Our Reference:
SWS-KENT-S106-010707

Date:
21/12/2017

Application to Connect to the Public Sewerage System - Section 106 Water Industry Act 1991. Location: 13A Queen Street, Deal, Kent, CT14 6ET.

PROJECT
Proposed Drainage Plan

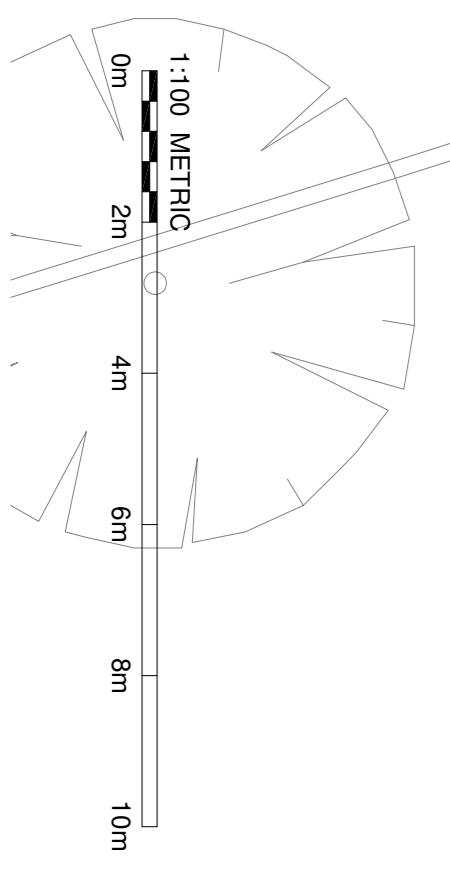
Further to your recent application to connect to the public sewerage system at the above location, we are pleased to inform you that your proposal to connect to the public foul sewers via existing manholes has been approved subject to the following provision: -

Connections to existing manholes and arrangement of pipe junctions within the manhole should be in accordance with Sewers for Adoption 7th edition and Southern Water guidance documentation.

- Please note, surface water must not communicate with the public foul sewers.
